West Midlands
Interchange

The West Midlands Rail Freight Interchange Order 201X
Applicant's Draft Response to ExA DCO and DCOB Comments (Agenda to ISH1)

ISH1 Agenda Annex 2 - Draft DCO – Structure, Definitions and Articles 1-49 (Agenda item 4)

1m SCALE 1:100

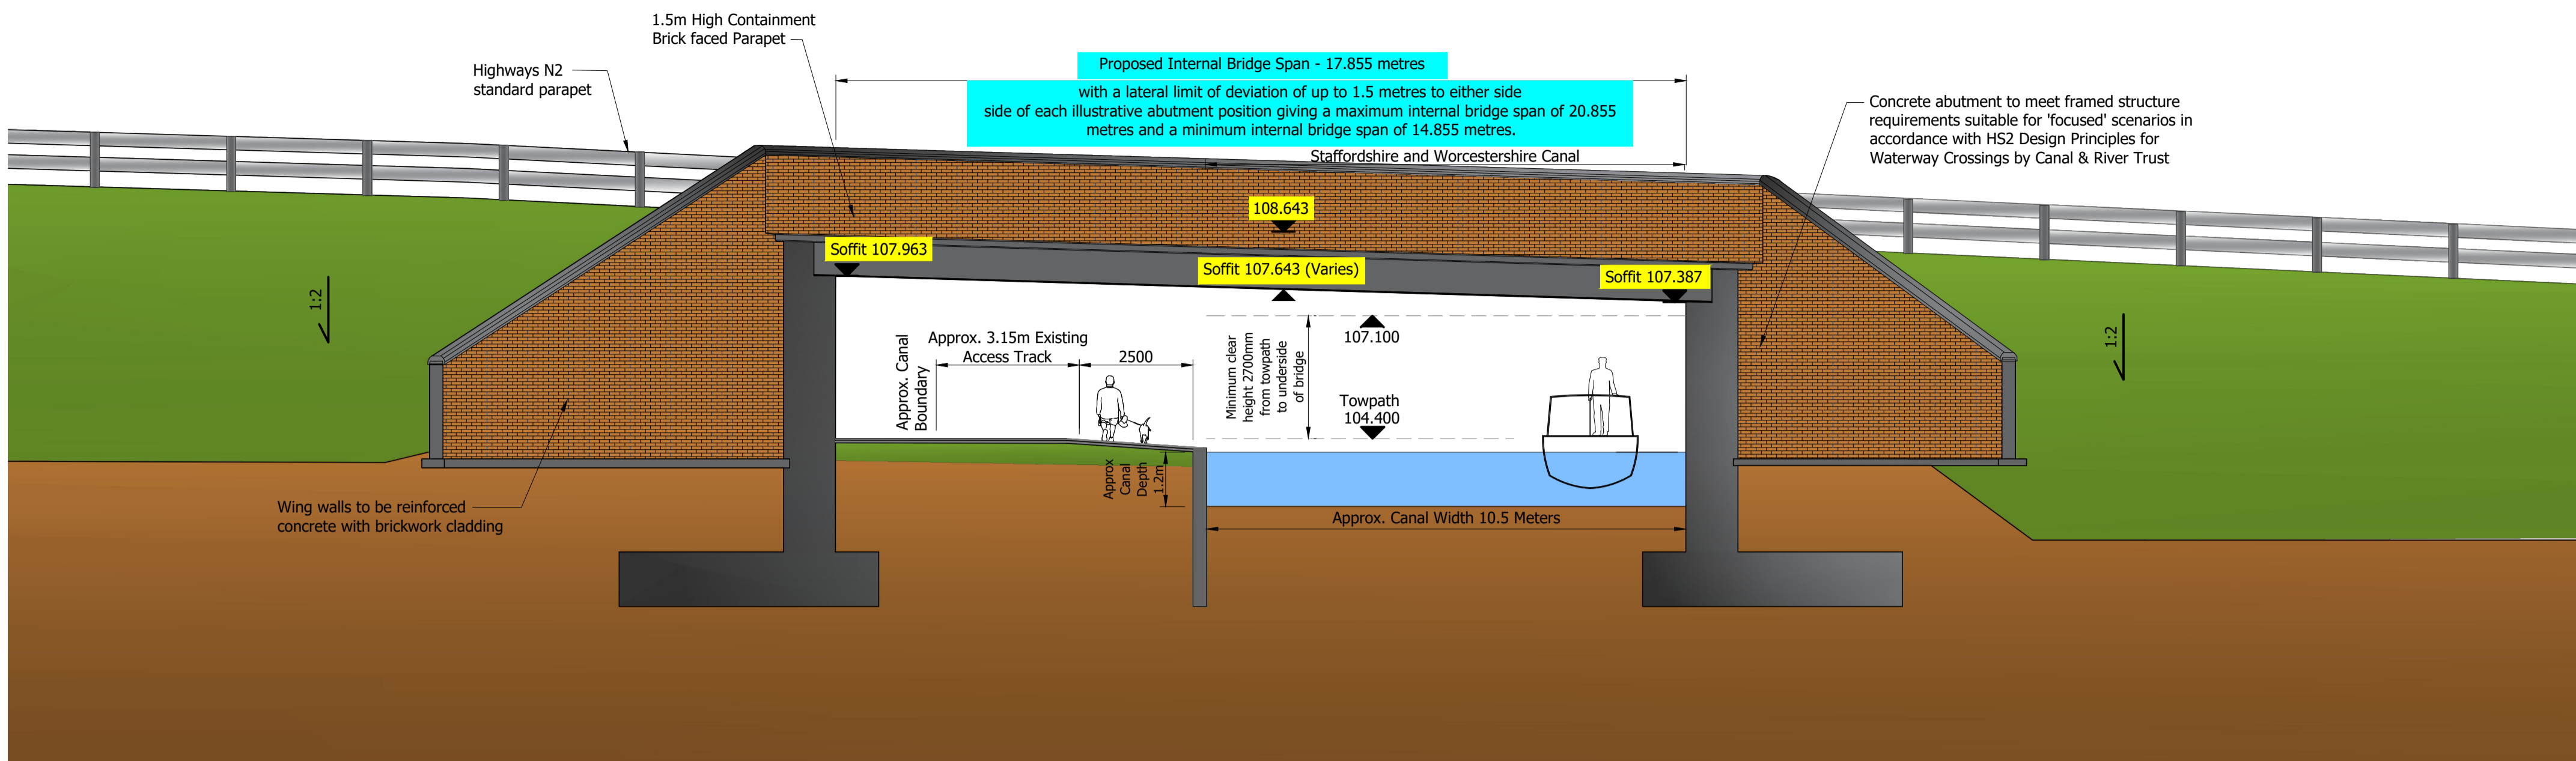
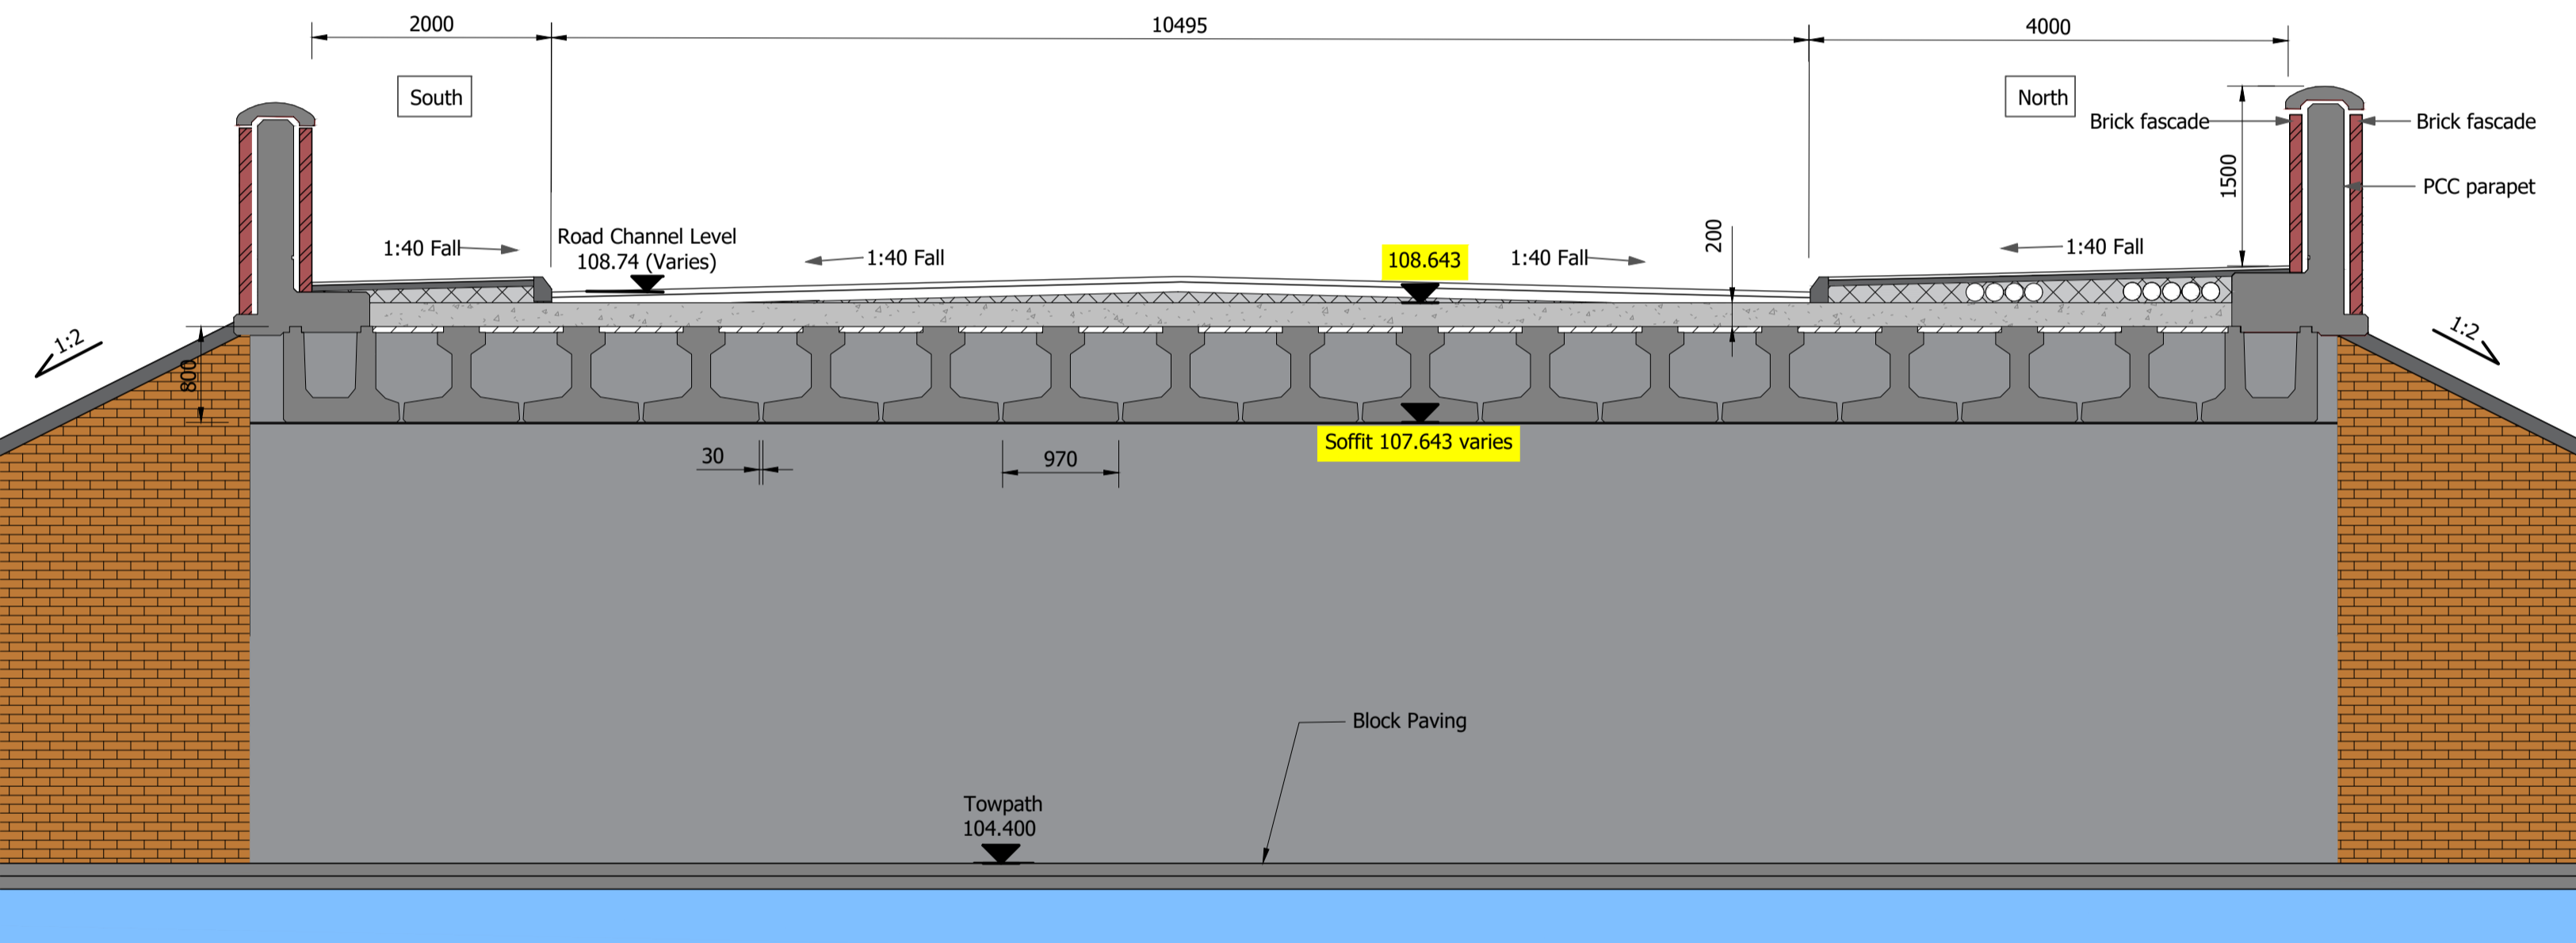
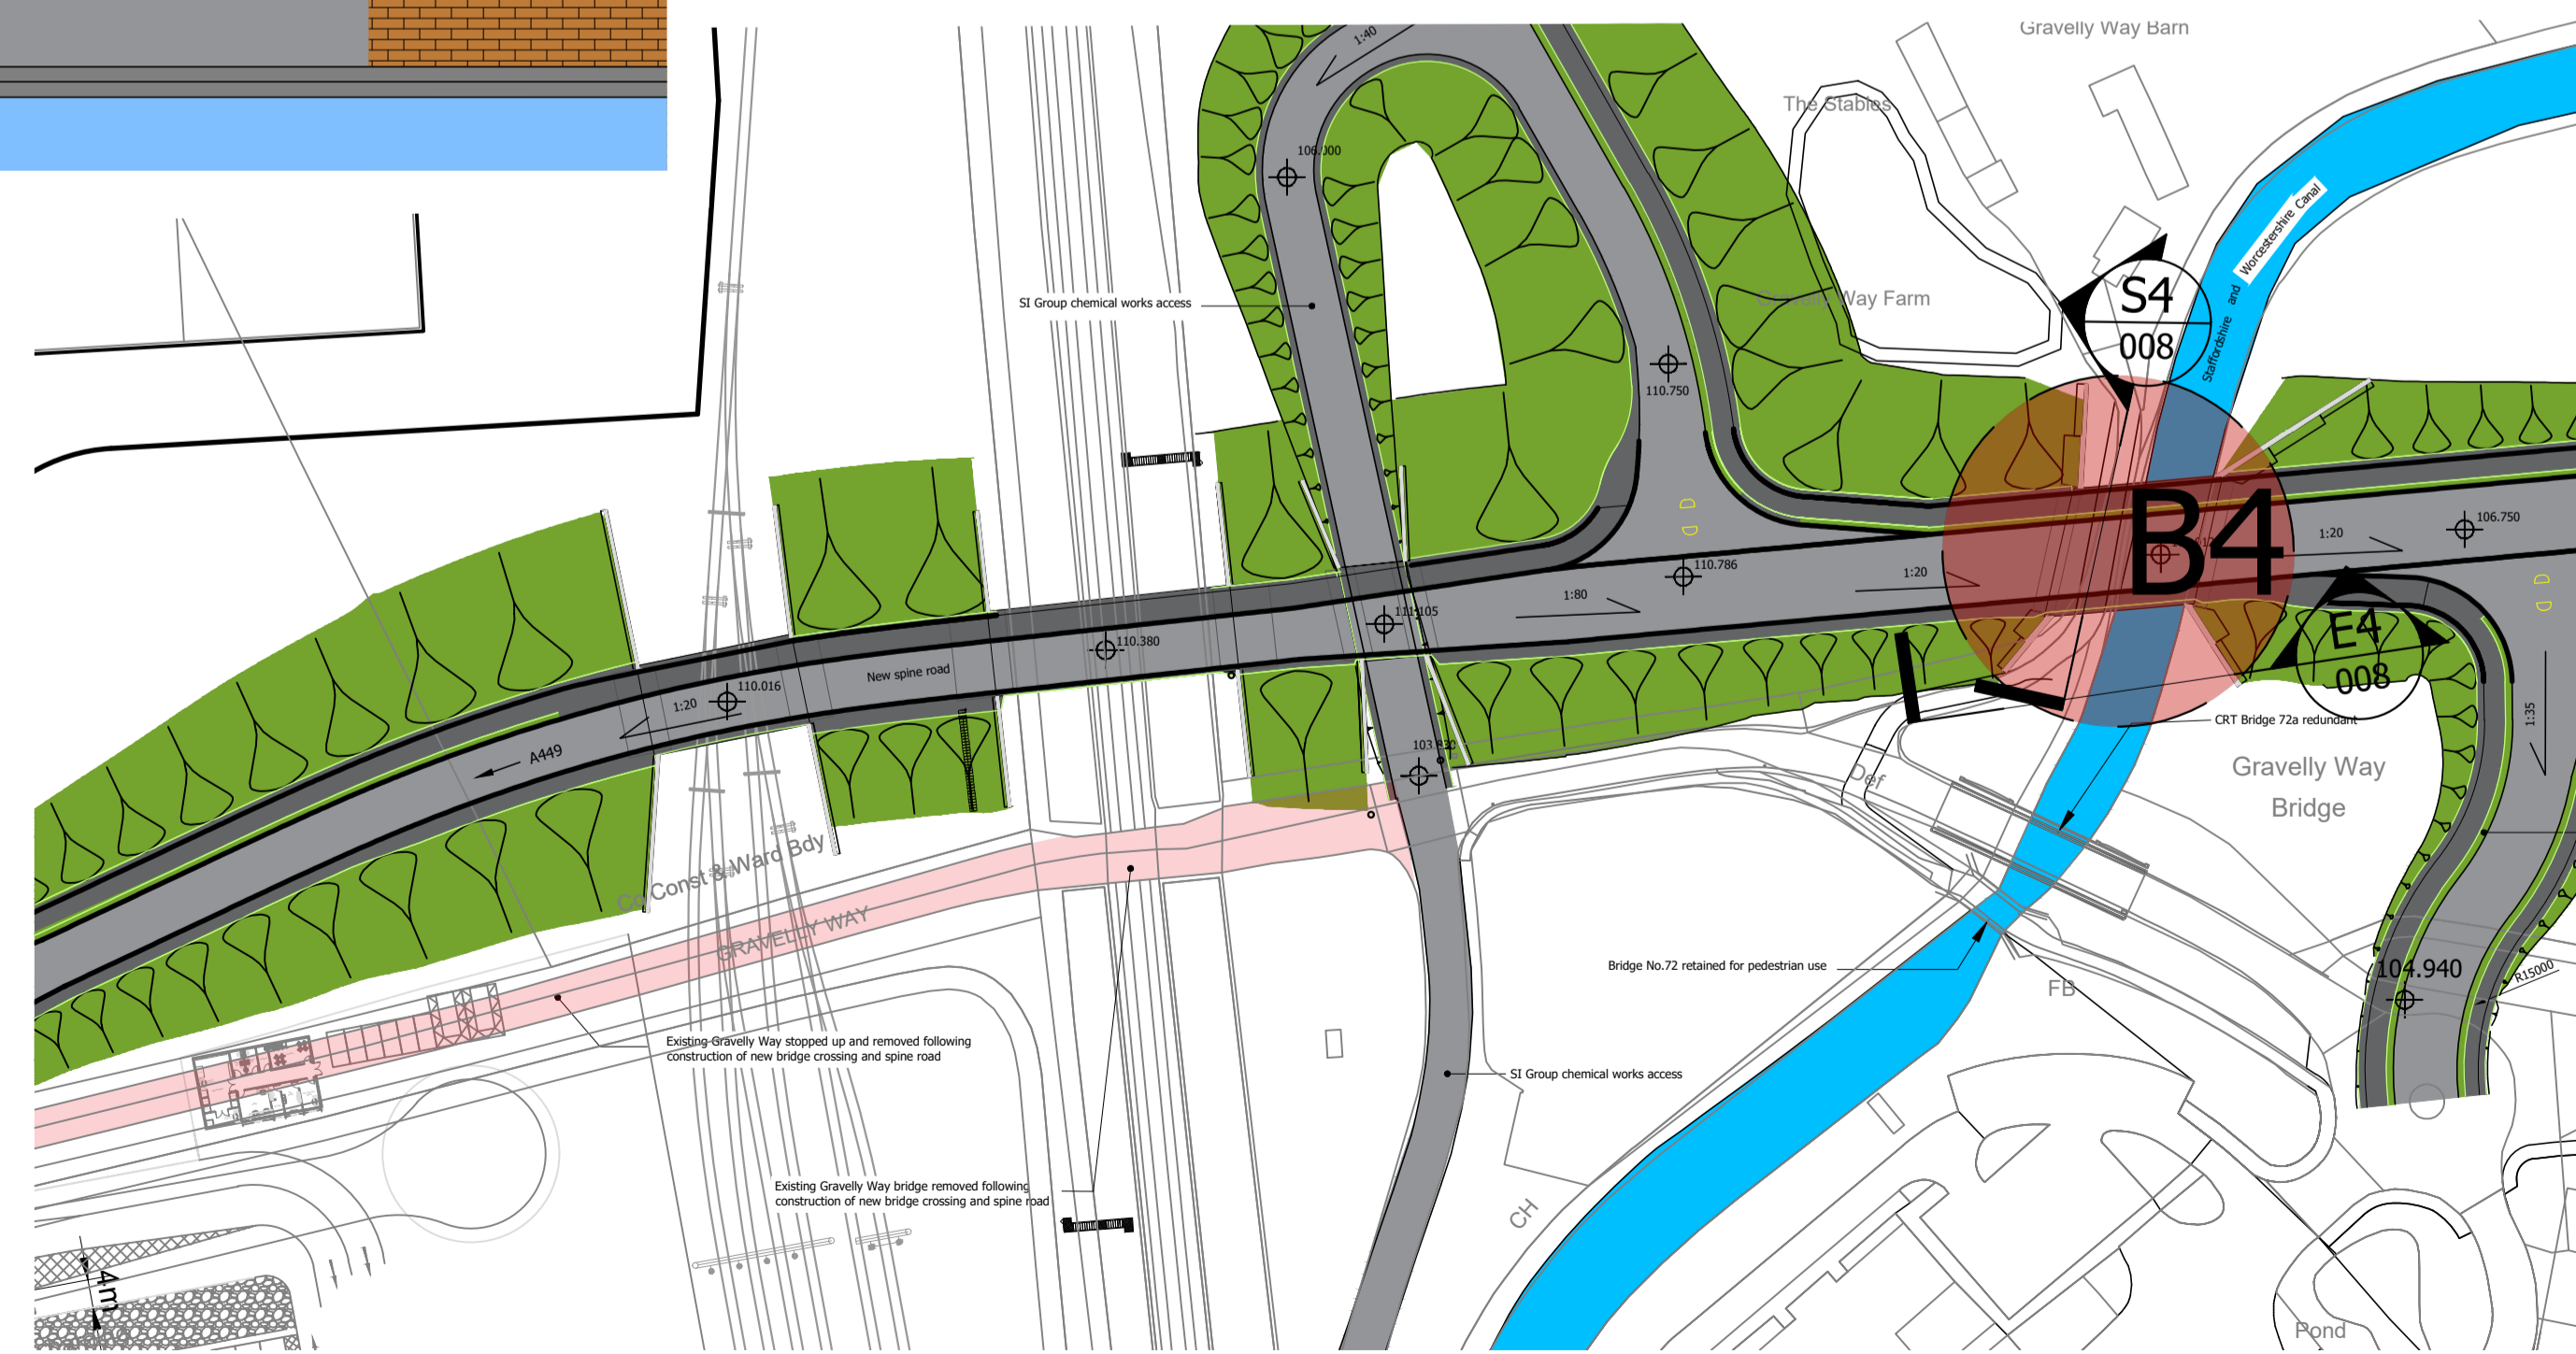
Q Ref	Part of DCO	Directed to	Question/ comment	Applicant's Response
1.10	A4	Applicant	<p>i) How would Clause (b) operate alongside the annotations on the Bridge Plans which indicate detailed levels for the underside, deck and other key elements of the proposed bridges and set minimum clearance levels for the underside of bridges?</p> <p>ii) Would there be a risk that the flexibility provided by Clause (b) might operate in tandem with that provided by Clause (c) (i.e. in relation to a bridge over part of the railway works) to result in an upwards deviation in the level of such a bridge by 3 metres?</p> <p>iii) Has the full degree of flexibility provided for in A4 been assessed in the ES on a worst case basis?</p>	<p>i) It is intended that the exact detail of the bridge design is to be approved before construction (requirement 3 will be amended to provide for that explicitly). The ExA will note that some of these annotations on the Bridge Plans refer to approximate distances. The maximum limits of deviation are required to ensure that the DCO allows for tolerance to accommodate normal variations required when construction details are known.</p> <p>ii) The Applicant does not consider that there is a risk of this, but will consider whether the wording of sub-paragraphs (b) and (c) might be suitably amended to alleviate any concerns. The railway works mentioned in sub-paragraph (c) specifically relate to Works 1 and 2, whereas the construction of the bridges is contained in Works 4. However, the Applicant understands the potential for confusion and suggests that article 4(b) is amended to refer to "bridges" rather than "bridge works", since the term "bridges" is defined with reference to the Bridge Plans.</p> <p>iii) The parameter plans make reference to the works plans and these, along with the stated variations in Article 4, have been considered in the ES where effects have been considered on a worst case basis.</p>
